From: Dan Grove <dan@grove.cx>
Sent: Friday, October 7, 2022 8:23 AM
To: Molly McGuire
Subject: An additional data point on 6950 Maker/File 2207-019

To further buttress the Existing Grade comments that I made about the 6950 project, I tried an experiment: I overlaid the 6950 house plans onto the site plans of 7145 SE 35th, the house immediately north of 6950 (and which we know was built on Existing Grade).

MERCER RESIDENCE
6950 SE MAKER ST MERCER ISLAND, WA

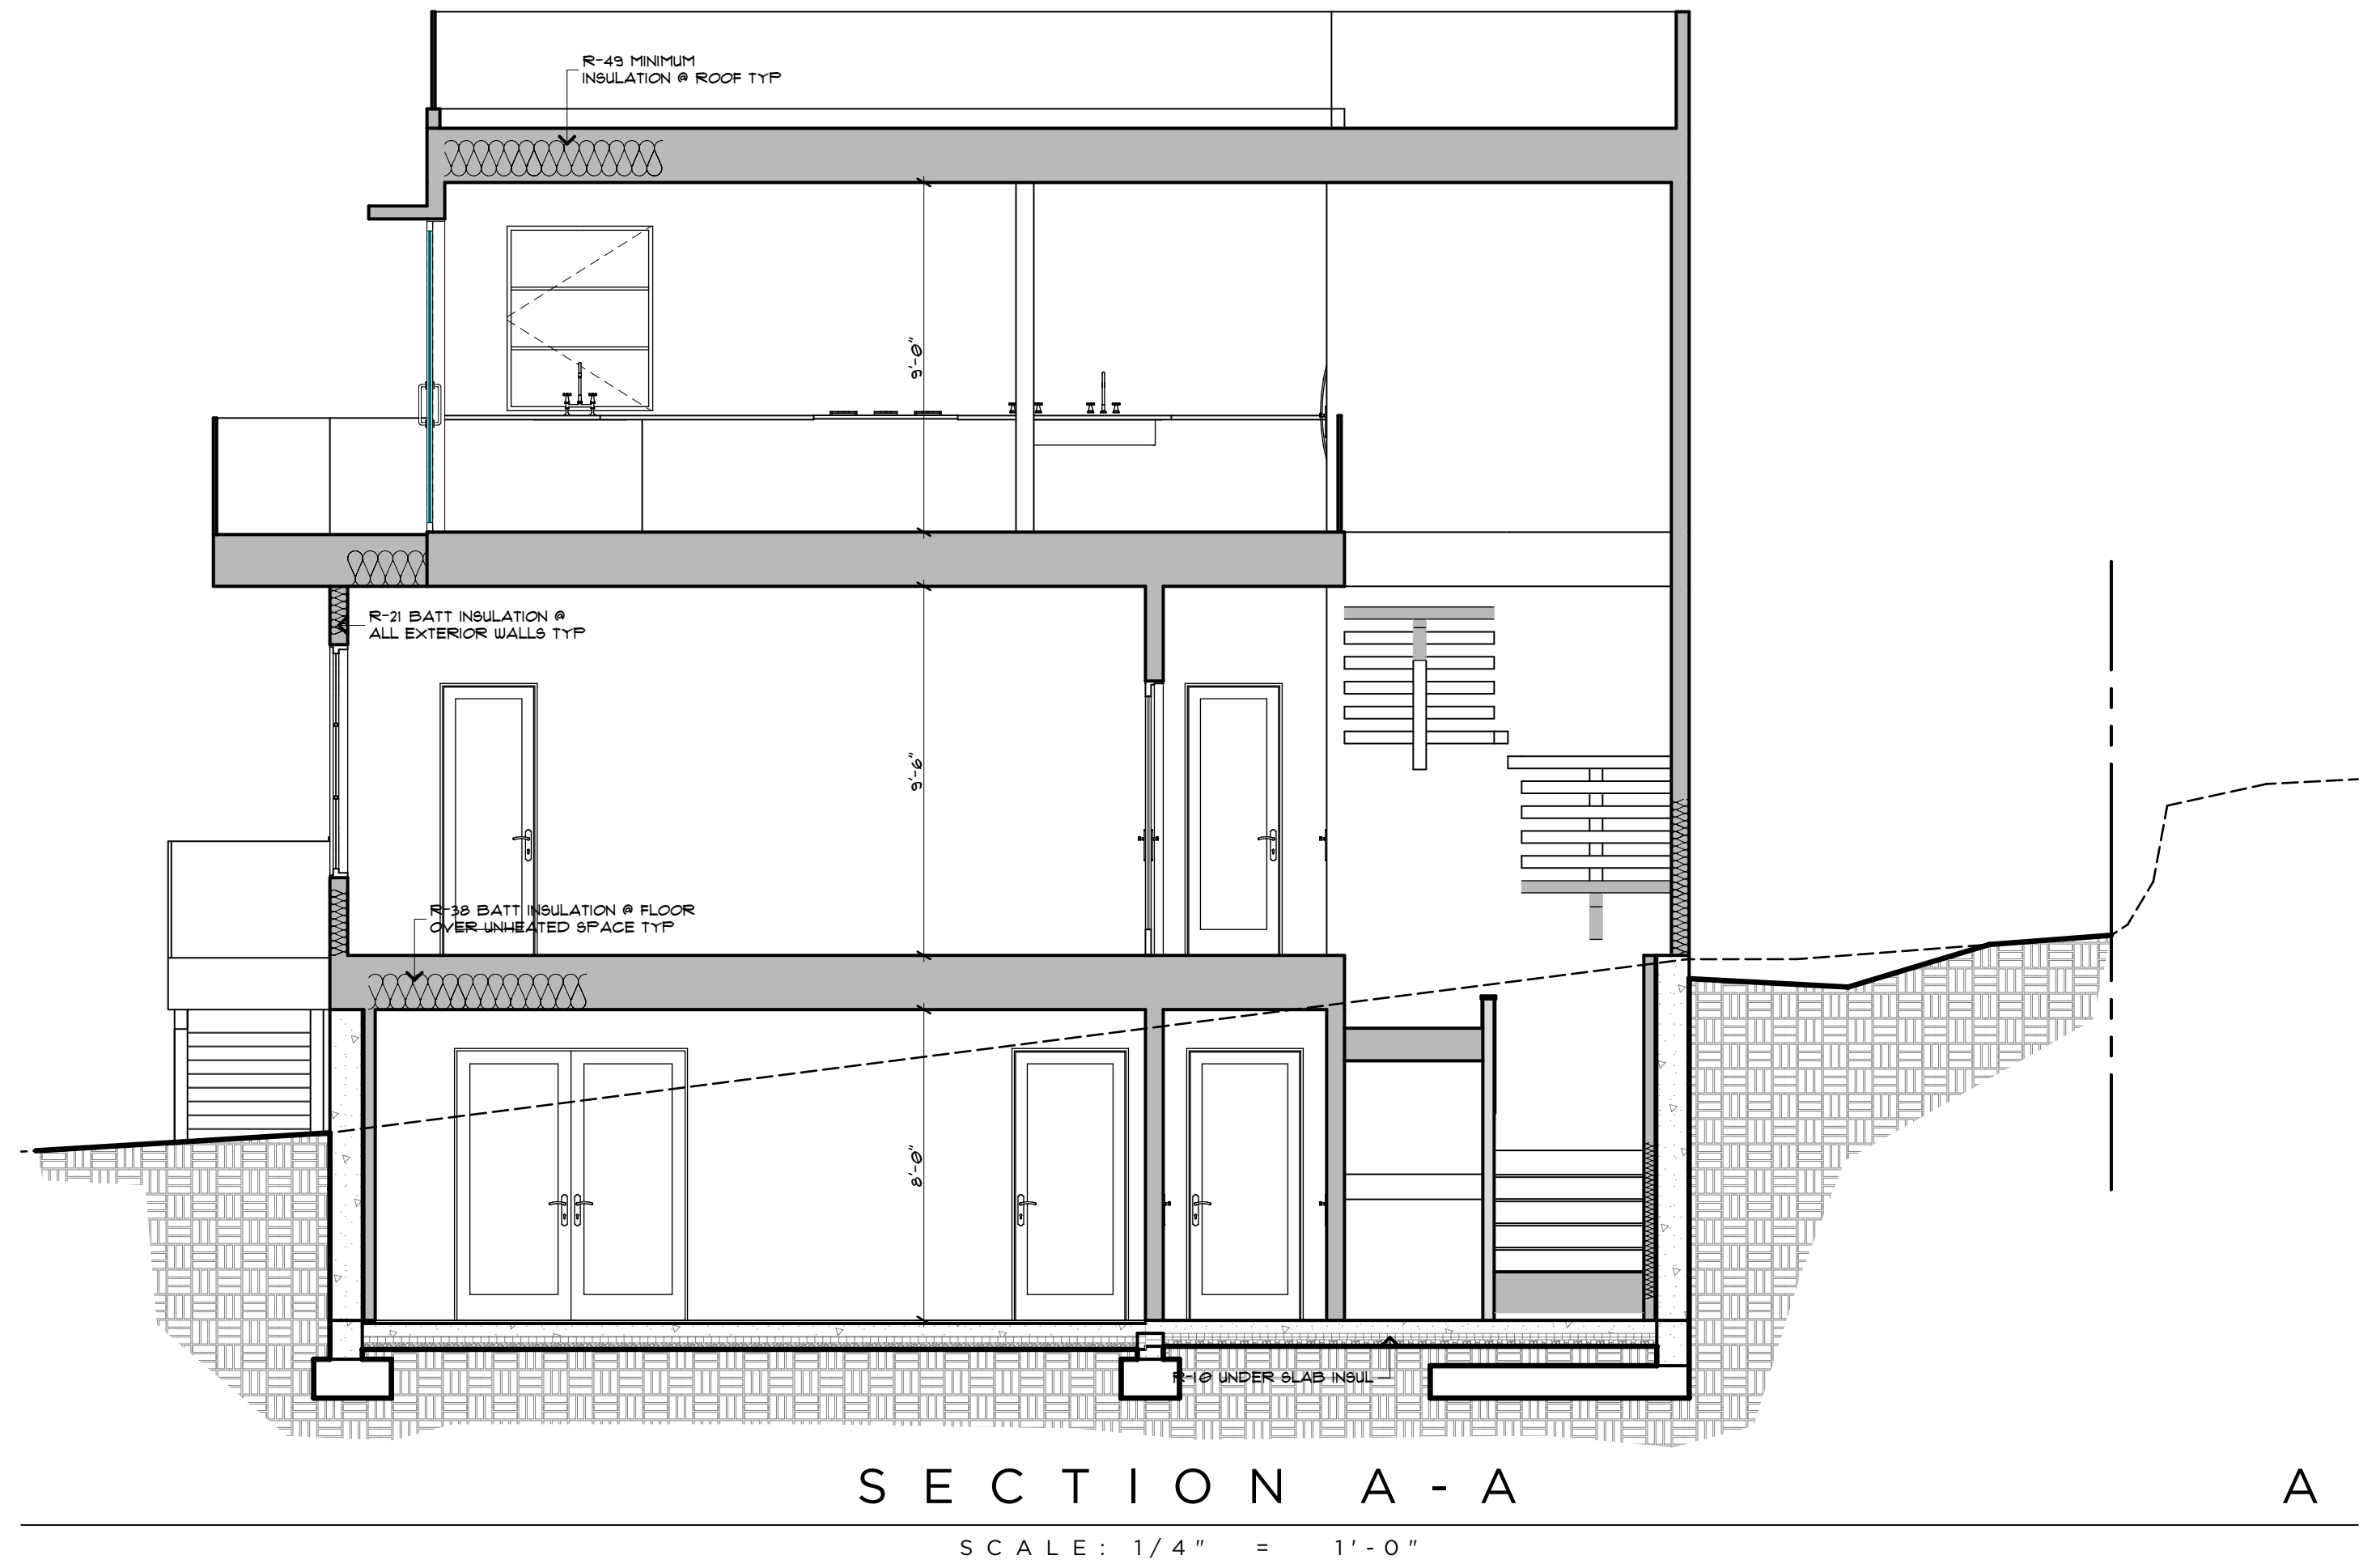
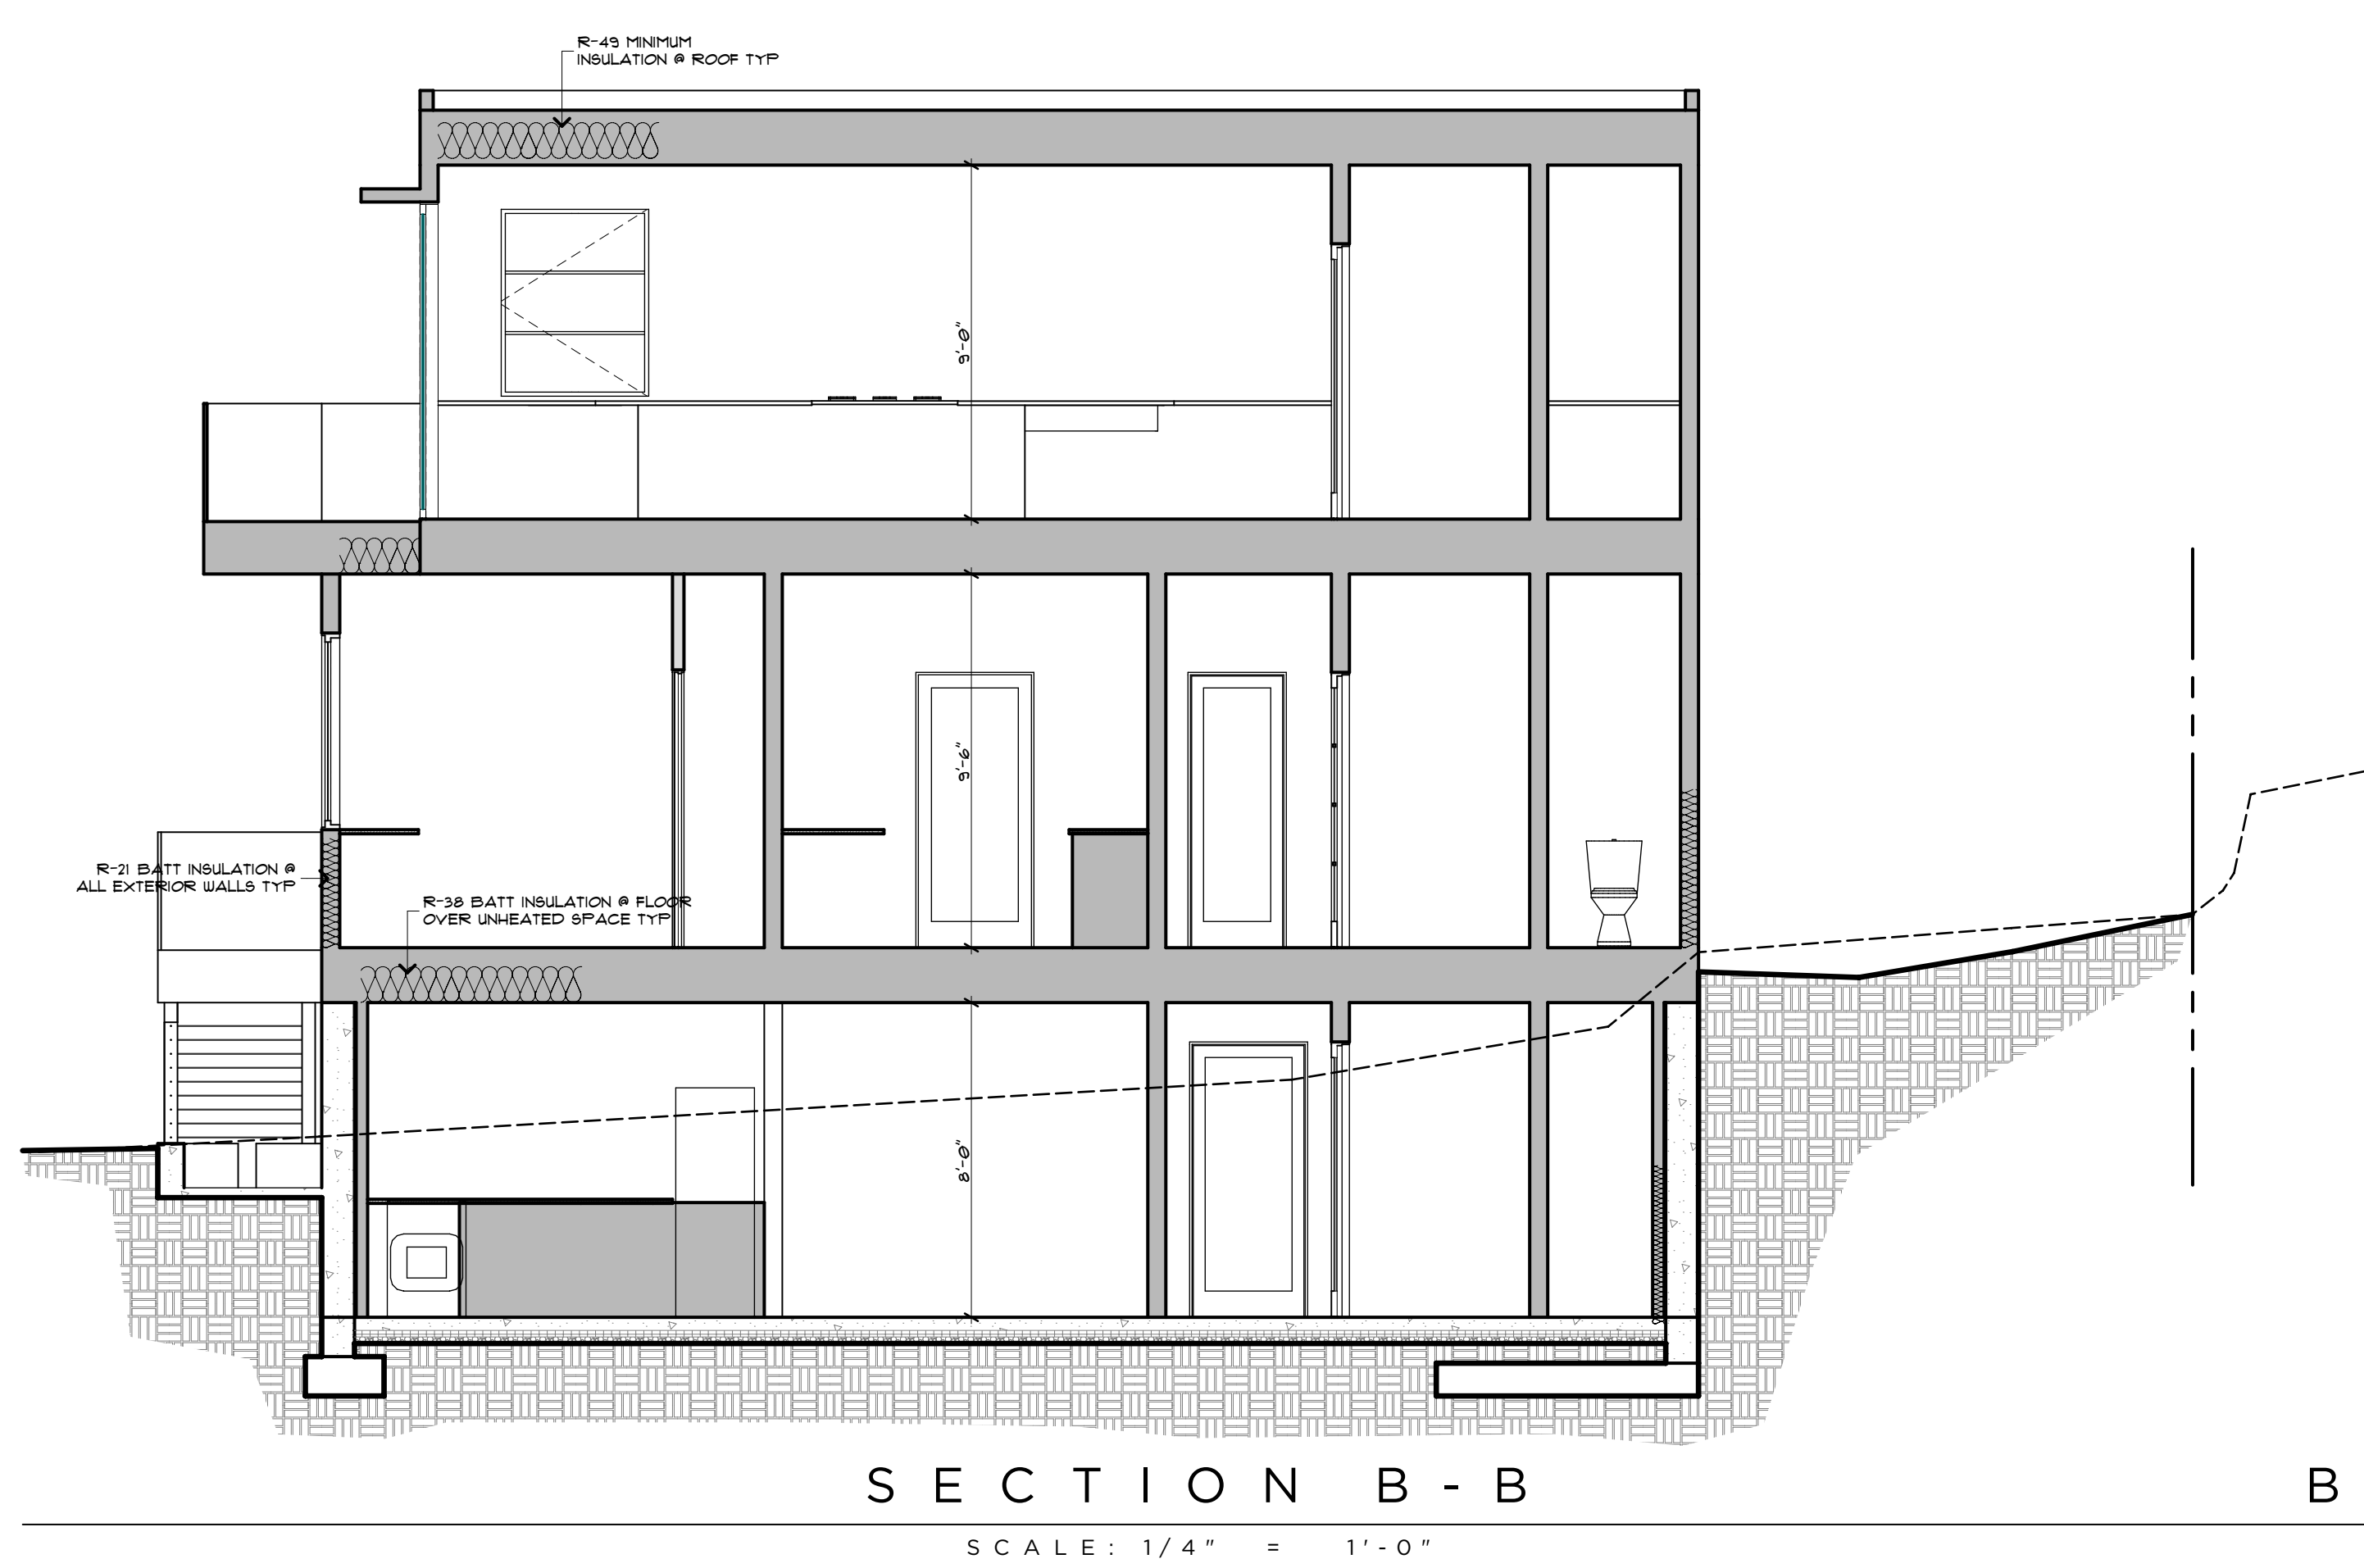
7145 is up the hill from 6950, but even on the 7145 lot, the 6950 project would have an ABE of ~229'. This is a good verification of the ABE that I presented in my formal comments.

You can see the outline of 6950 house (placed with the same borders N, S, E on the 7145 lot) in yellow, and the approximate ABE at the intersection of the red lines.
